**NORTH YORKSHIRE COUNTY COUNCIL  
BUSINESS and ENVIRONMENTAL SERVICES**

**LOCAL HIGHWAY AUTHORITY  
CONSIDERATIONS and RECOMMENDATION**

**Application No:** **2021/22459/ADV**

**Proposed Development:** New external post sign

Aluminium composite sign  
1000 x 1000mm with vinyl graphics

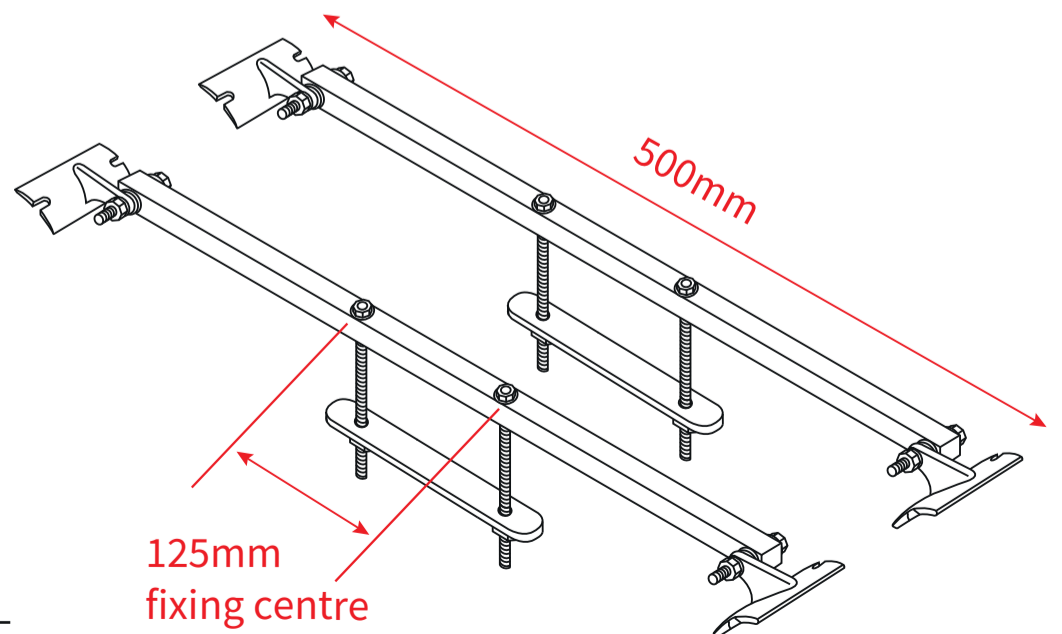
You are advised to ensure that any projection overhanging the footway is securely fixed and no part is less than 2.4 metres above the footway level and no closer than 0.5 metres to the edge of the carriageway.
